WELWYN HATFIELD BOROUGH COUNCIL – DEVELOPMENT MANAGEMENT
DELEGATED REPORT

APPLICATION No: W6/2015/1321/EM

SITE ADDRESS: 13 Sherrardspark Road, Welwyn Garden City, AL8 7JW

DESCRIPTION OF DEVELOPMENT: Alterations to replace window with French doors to rear elevation and installation of two windows to side elevation

SIDE ELEVATION

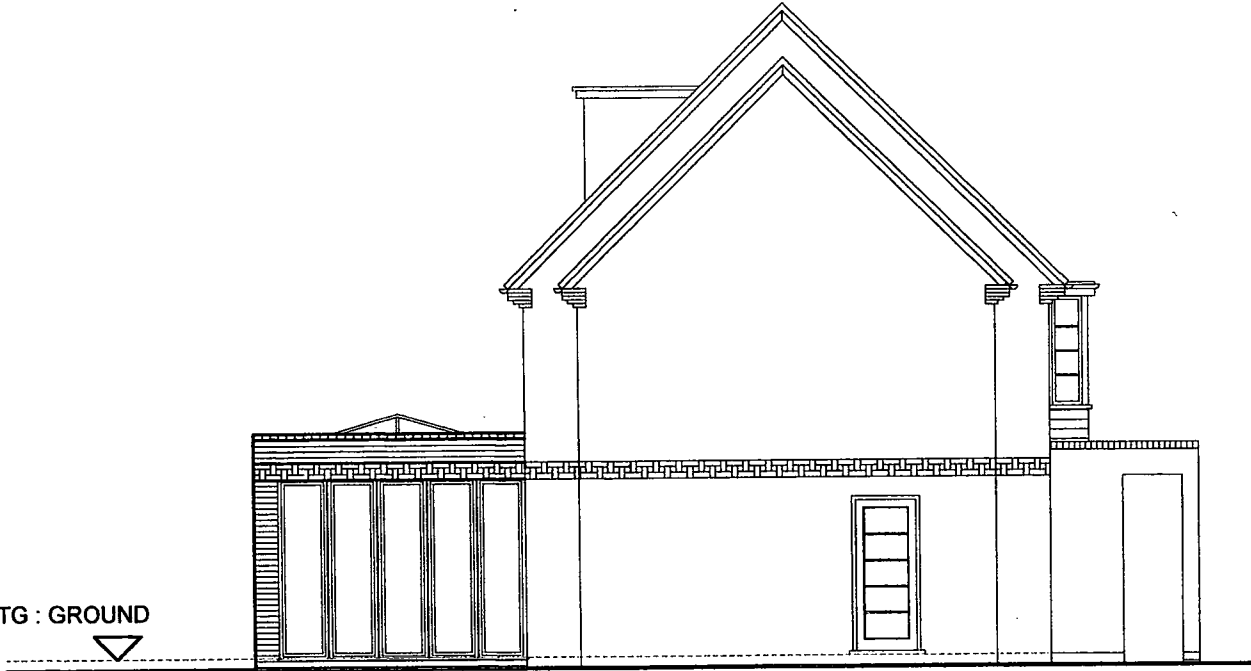
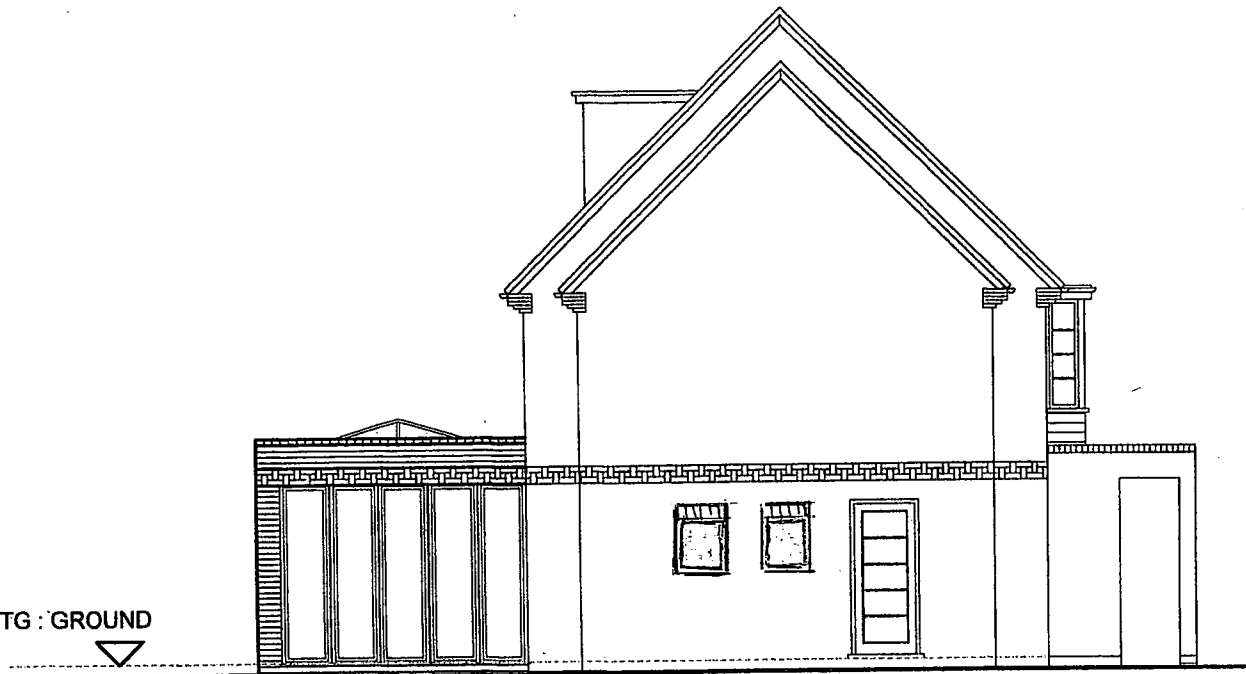
Additionally the applicant proposes the installation of two windows to the side elevation. Whilst this alteration does change the fenestration from the original appearance of the dwelling its impact would not be so unacceptable to warrant a refusal given they are at ground floor level, to the side where they are not visible from a public vantage point.

# PROPOSED KITCHEN LAYOUT 13, Shenvards Park Road

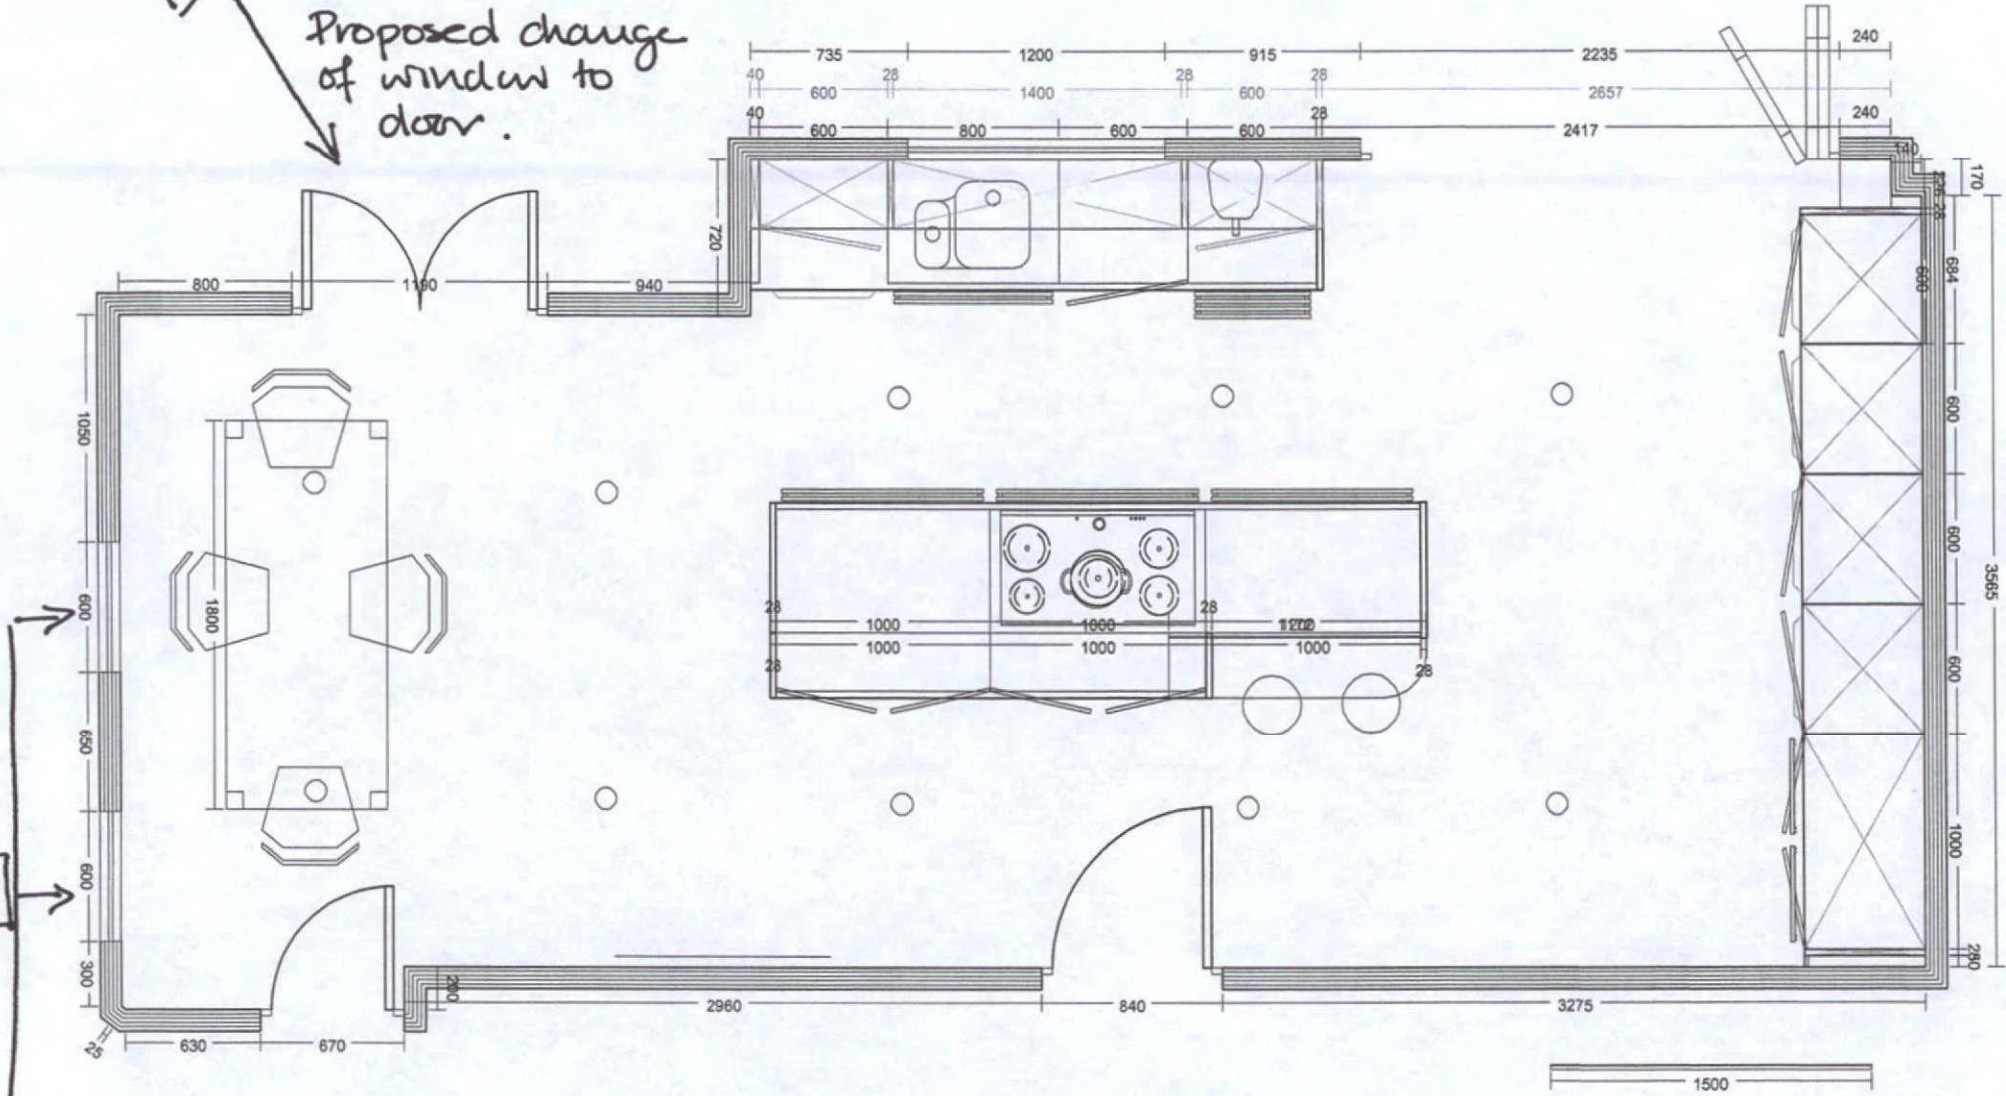
The applicant proposes replacing an existing rear ground floor window with new French doors. The proposal would retain the existing height, width and setting of the window, but would extend further to ground level.

The proposed rear window alteration would change the ground floor fenestration from that of the original appearance of the dwelling. Its impact would not be to the extent to warrant a refusal by virtue of it being at ground floor level and to the rear where it would not be visible from a public vantage point. Furthermore the proposed Window is in keeping with the existing window design and would be conditioned in the event of an approval.
